Our Ref: EN010142

Date: 08 May 2024

### **Application by Tillbridge Solar Limited for an Order Granting Development Consent for the Tillbridge Solar Project**

#### **Advice following issue of decision to accept the application for examination**

FIGURE NUMBER
Figure 10-5

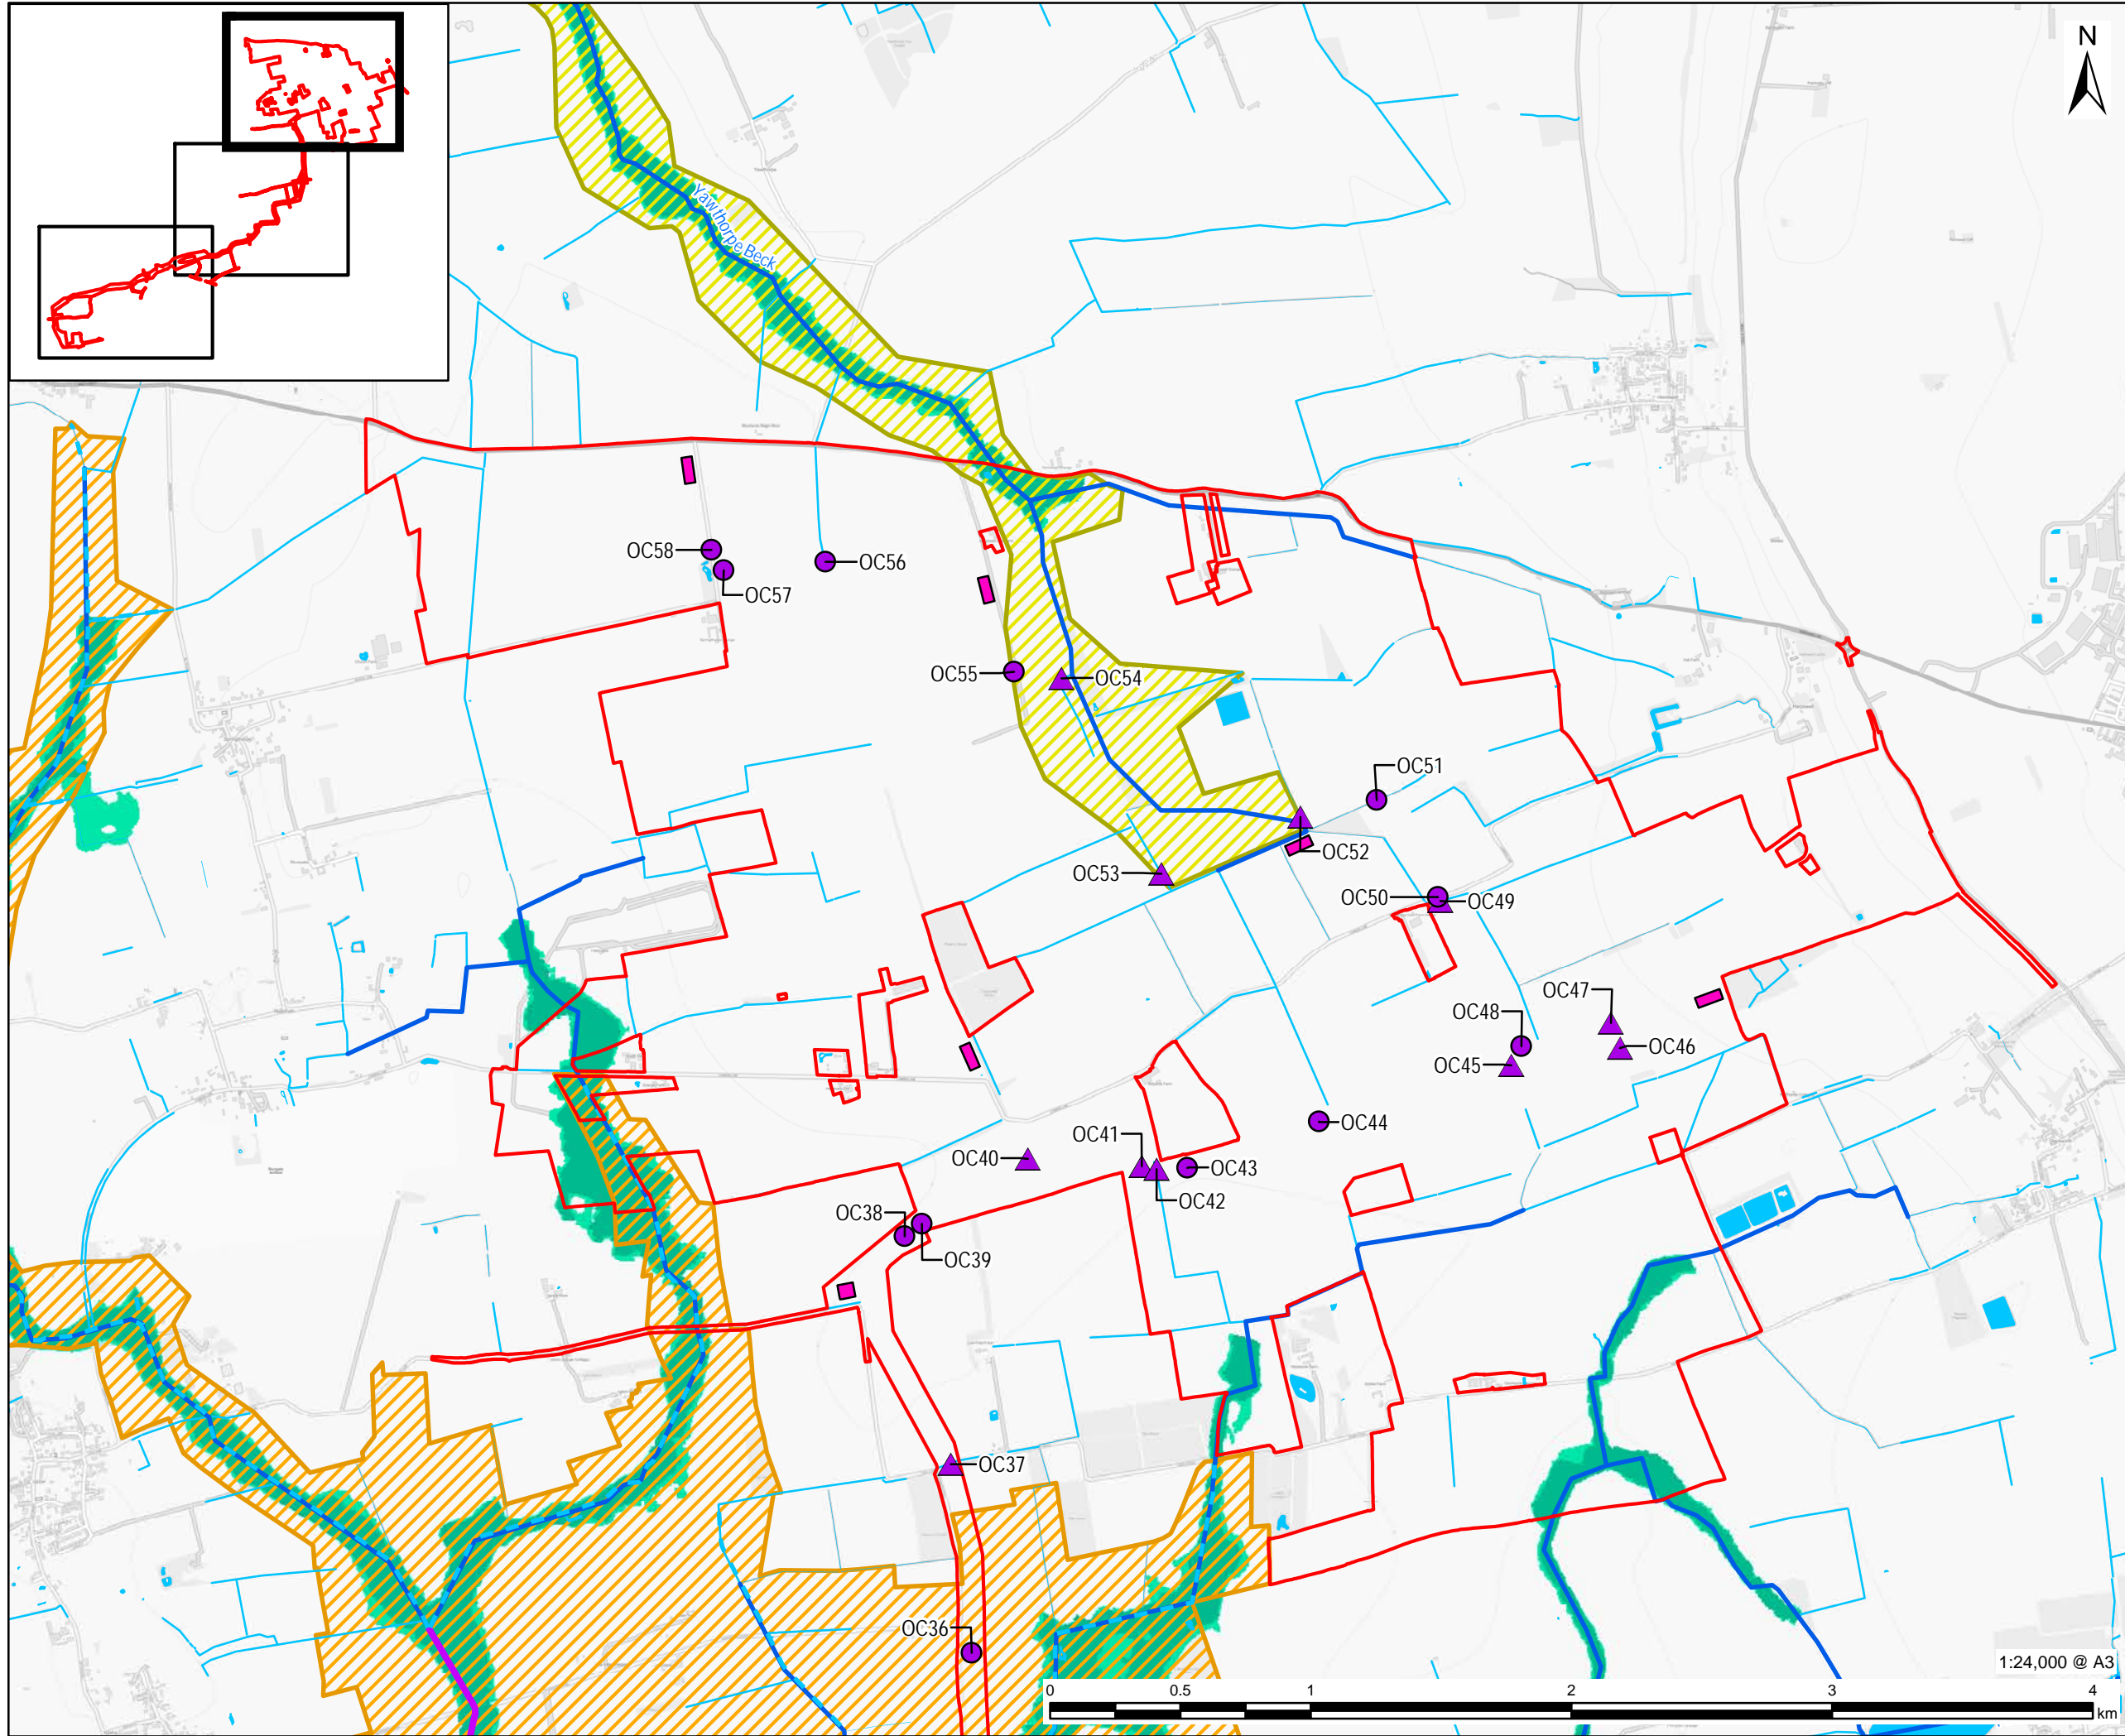
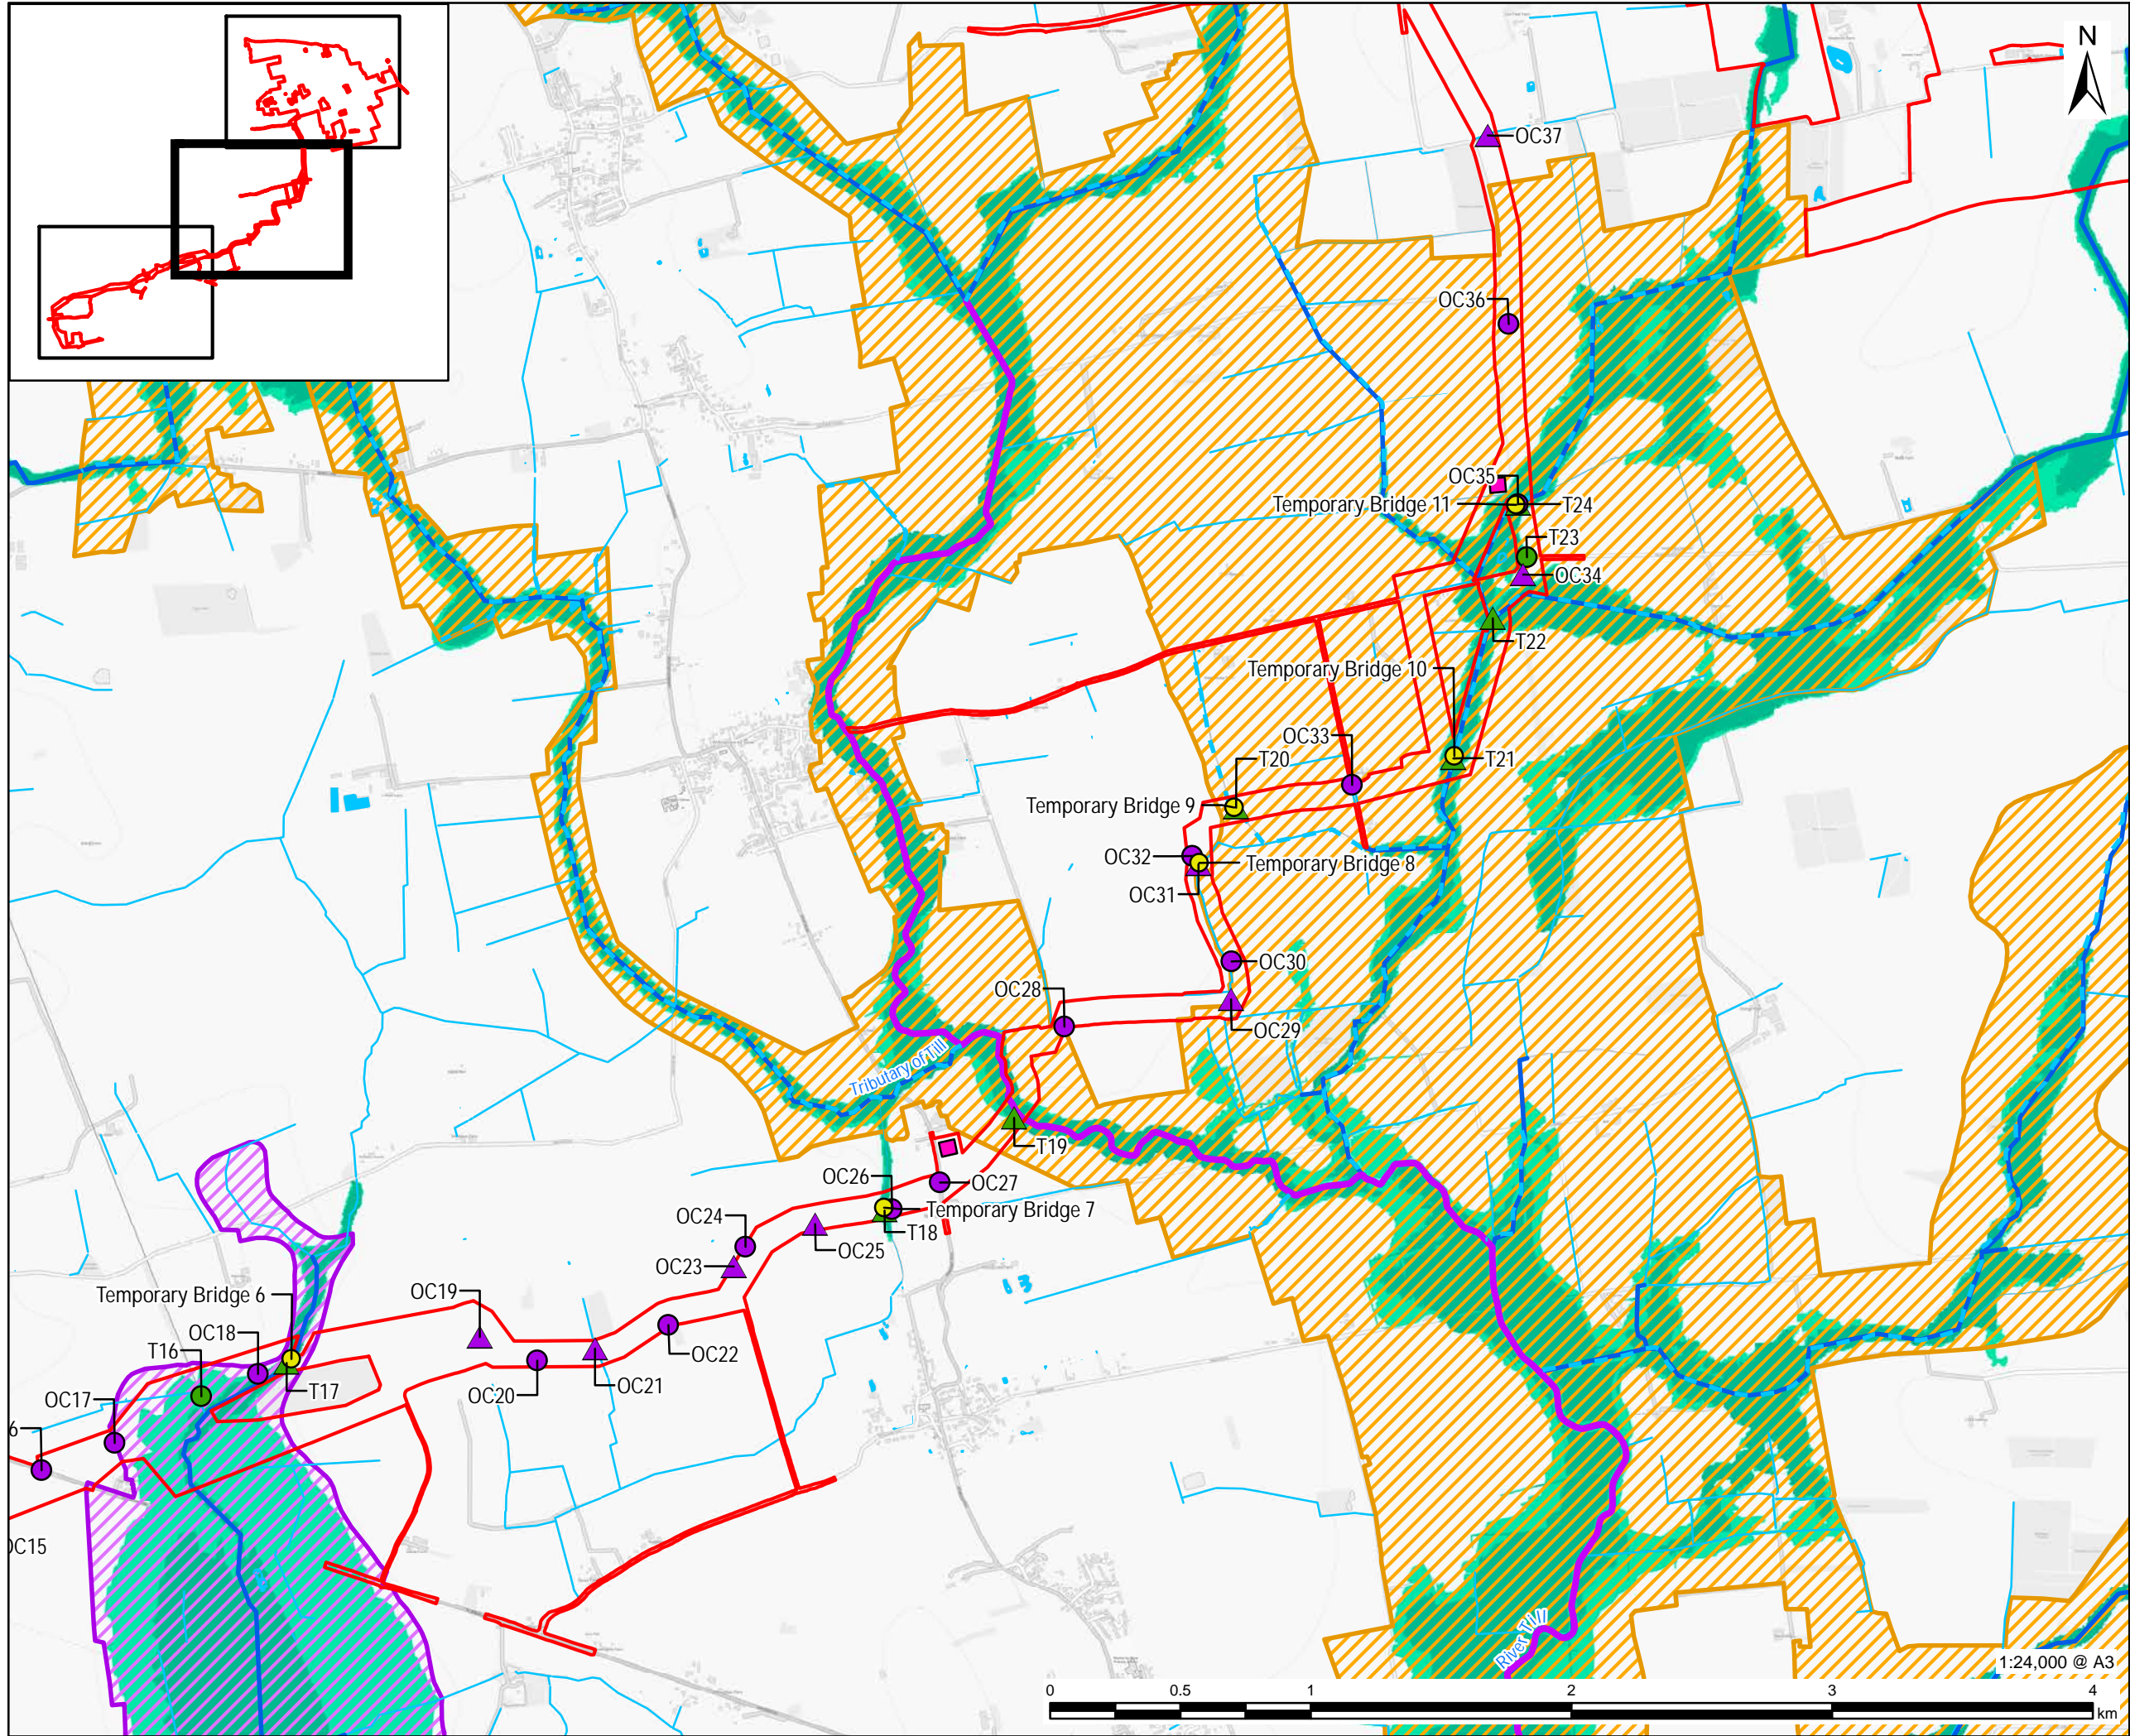
It is noted that all chapters, appendices and figures have the same document reference 6.1 to 6.3 which may make them difficult to search within the Examination Library.
